Sent: 28 October 2025 19:37
To: Louise Bearcroft <Louise.Bearcroft@kirklees.gov.uk>; DC Admin <DC.Admin@kirklees.gov.uk>
Subject: Objection

Re: Kirklees Planning Applications: 2025/44/92737/E and 2025/61/92713/E

Site address: Rear of, 23 to 43, Moor Lane, Gomersal, Cleckheaton, BD19 4LF

Client: PPJ Developments
Project Name: Land rear of 23-43 Moor Lane, Gomersal, Cleckheaton, BD19 4LF
Drawing Title: Drainage Plan
Purpose: S3 - For Comment
Scale: 1:250
Drawn: MA
Checked: ZS
Approved: ZS
Date: 26/09/2025

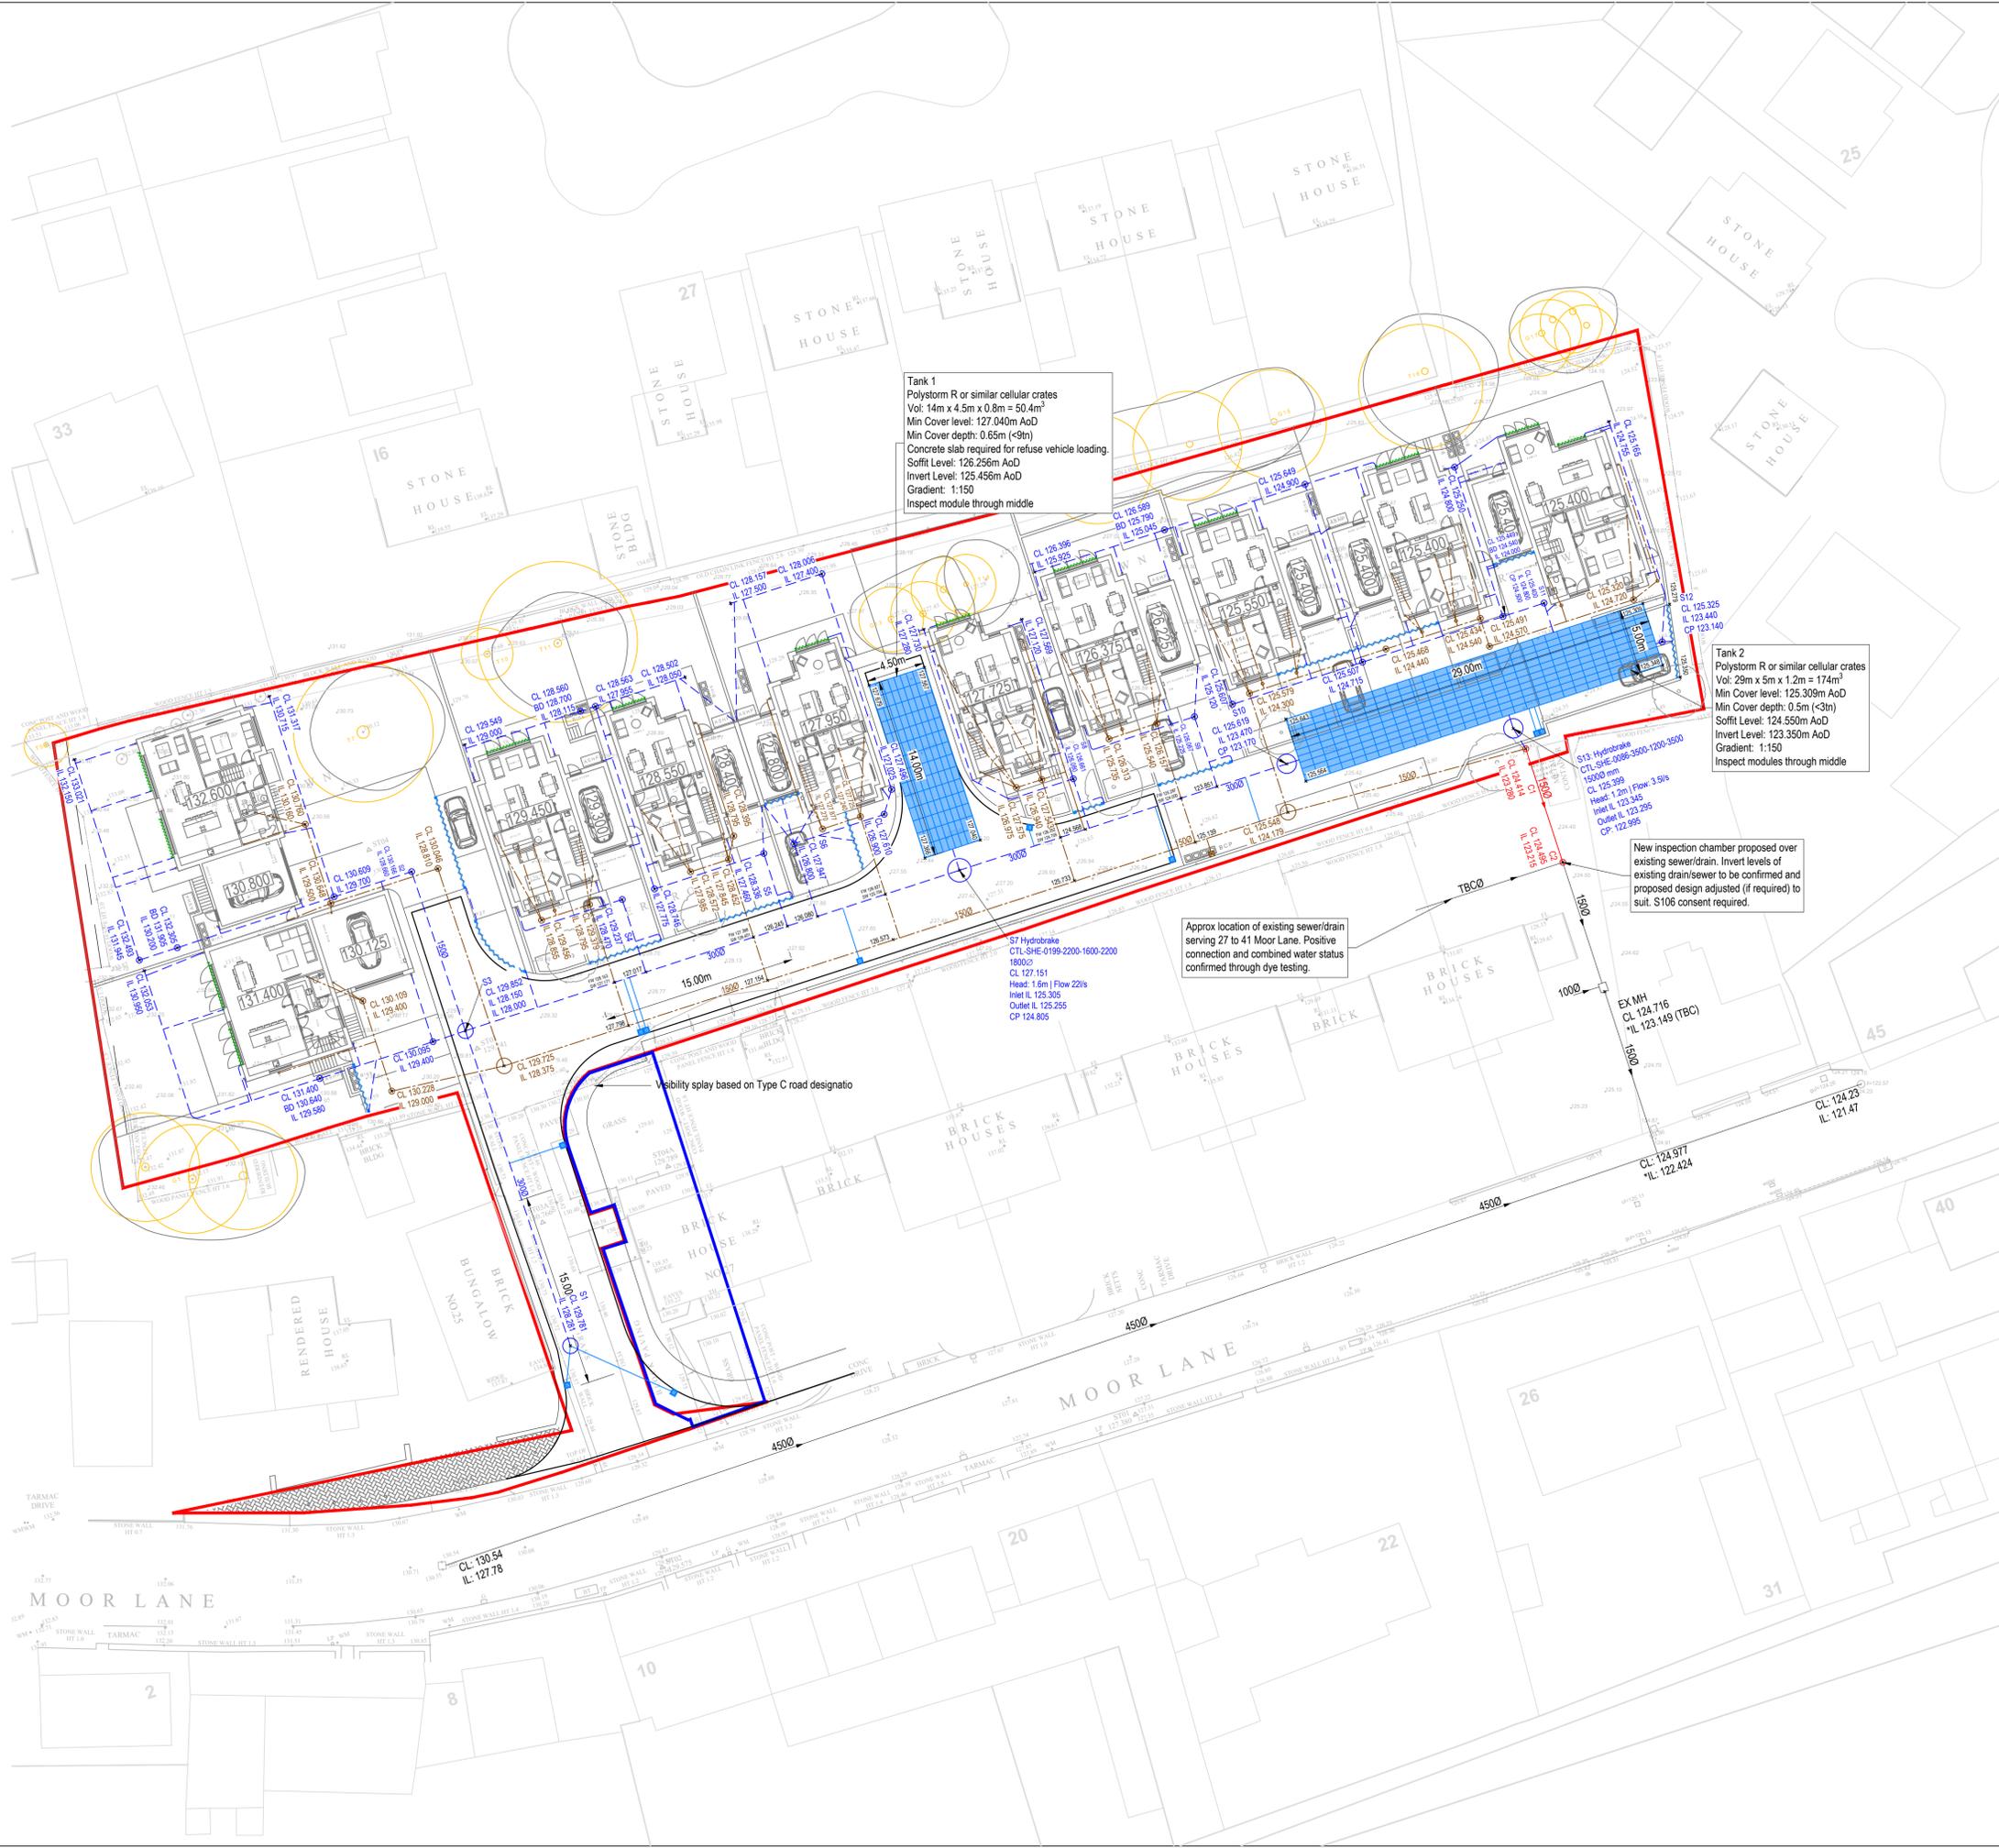
The current drainage plan show some kind of plastic crates located in two locations. The builder is channelling surface water down, through the site via these crates, towards existing residential properties. A new single 6 inch pipe will then carry both surface water and foul sewerage water, together, to a Yorkshire Water's drain in Moor Lane. We are extremely concerned as to whether this single 6 inch pipe will have the capacity to carry both the foul sewerage and the surface water, together, from this major development. Failure of this pipe will be catastrophic for all the residents in the local vicinity.

This drainage system plan does not meet Yorkshire Water stipulation specified in their consultation letters regarding this site. Two of their letters, Y.W. Ref: Y013884 and Y005783, both state: "The site shall be developed with separate systems of drainage for foul and surface water on and off site." (Both of these, on Kirklees Planning Website).

This developer is removing surface water and foul sewage from this site via one 6 inch single pipe, so is not complying with Yorkshire Waters conditions.

In a box on the Drainage Plan. This states: “**Junction connection to existing combined sewer. No other sewers present in the road (contrary to YW Mapping). S106 consent required. Invert level to be confirmed. Levels shown are inferred between manholes along Moor Lane only.**”

It does not seem logical, that Yorkshire Water does not know its own mapping, C Roberts, YorMap, 87 2582, supporting document from Yorkshire Water, clearly shows two pipes in Moor Lane. Therefore this brings into question whether the developer’s statements and knowledge, on these drainage plans, are viable and correct.

Yorkshire Waters website states “Please note that foul water must not be disposed of to a surface water sewer and surface water should generally not be discharged to a foul or combined sewer.” On these drainage plans, the developer is showing just **one 6 inch pipe** discharging both foul and surface water via one pipe into one sewer in Moor Lane. Therefore this developer seems to be acting contrary to Yorkshire Waters advice. Moor Lane already suffers from excess water flow on the road during continuous heavy rain and probably the existing drain is already struggling to cope. These drains have already had extra pressure put on them from the 10 apartments recently connected from the Silk Mill conversion on Moor Lane.

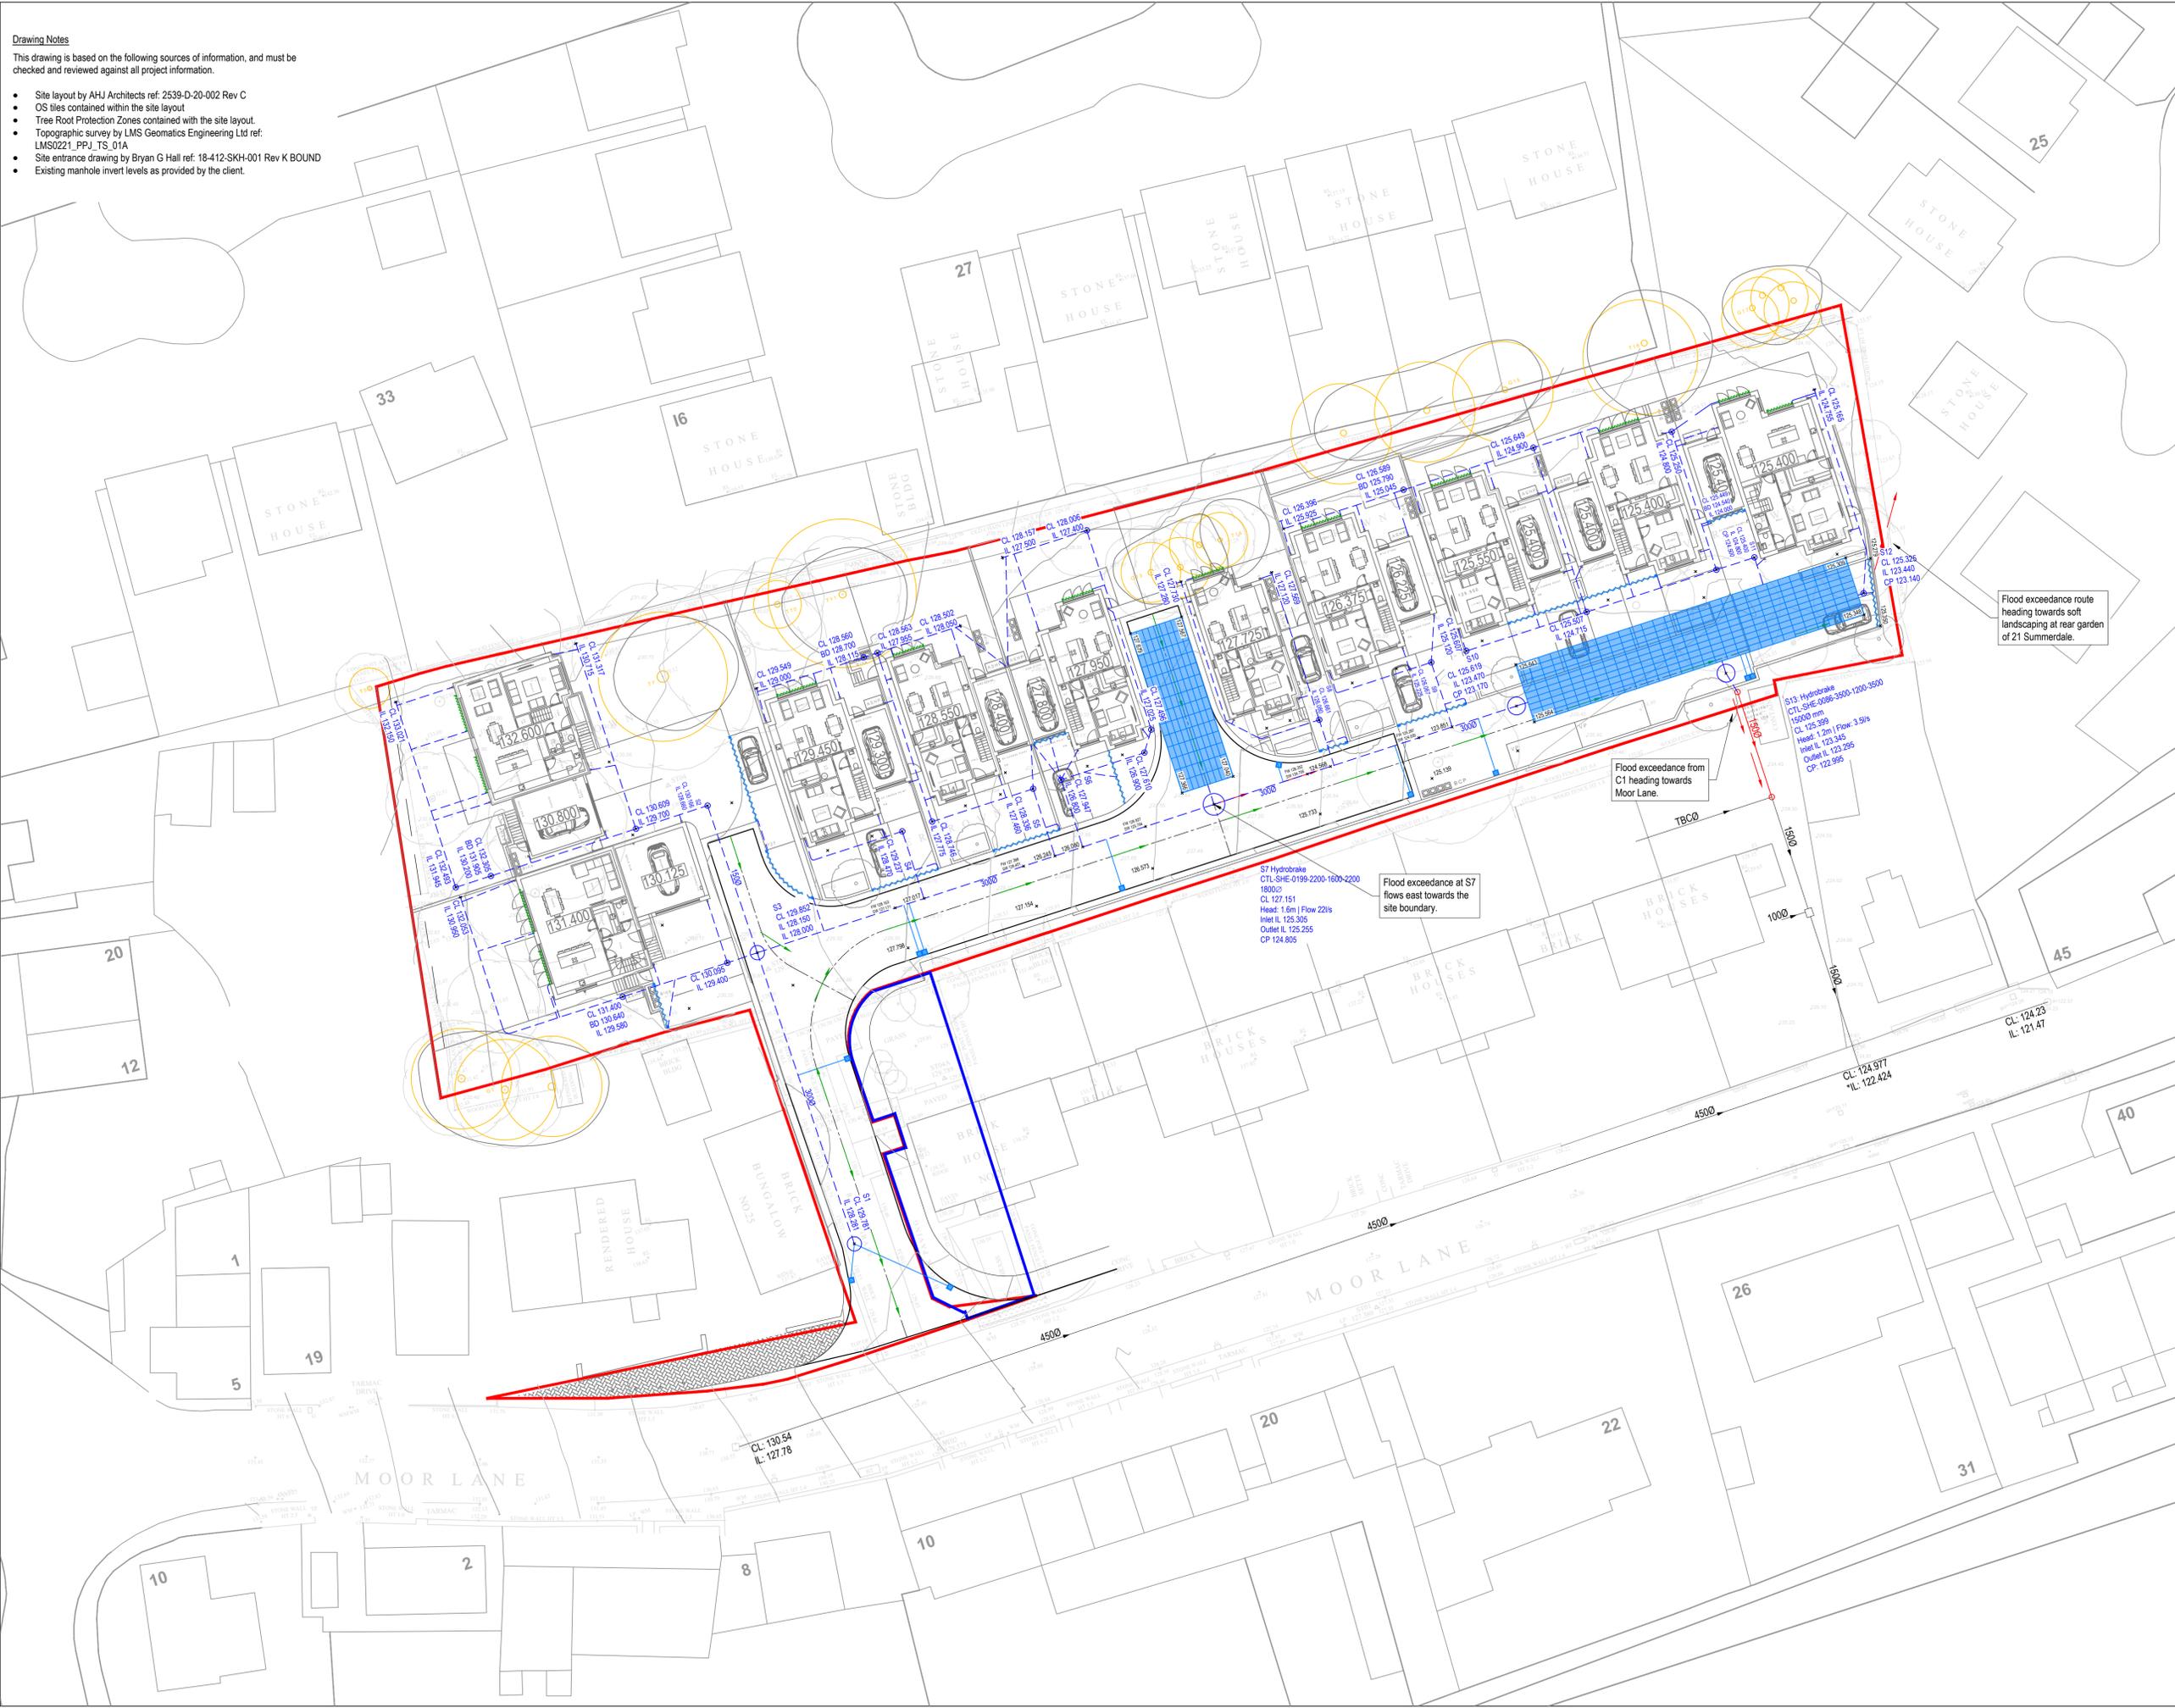
On the Flood Exceedance Plan there is a box that states the following:

"Flood exceedance heading towards soft landscaping at rear garden of 19 Moor Lane"

There is a red arrow on the plan pointing to the boundary of existing properties on Summerdale but on this plan it states 19 Moor Lane. The house, number 19 Moor Lane, is approximately 250 – 300 metres away, west of this point, up the hill (Moor Lane). The actual address that the arrow is pointing to is in Summerdale.

It is not acceptable, that on a Flood Exceedance Plan, a developer can show that flood excess water will flow into existing, neighbouring residents private gardens. We believe that this drainage plan is illegal and is **NOT** up to the required standard and **NOT** acceptable.
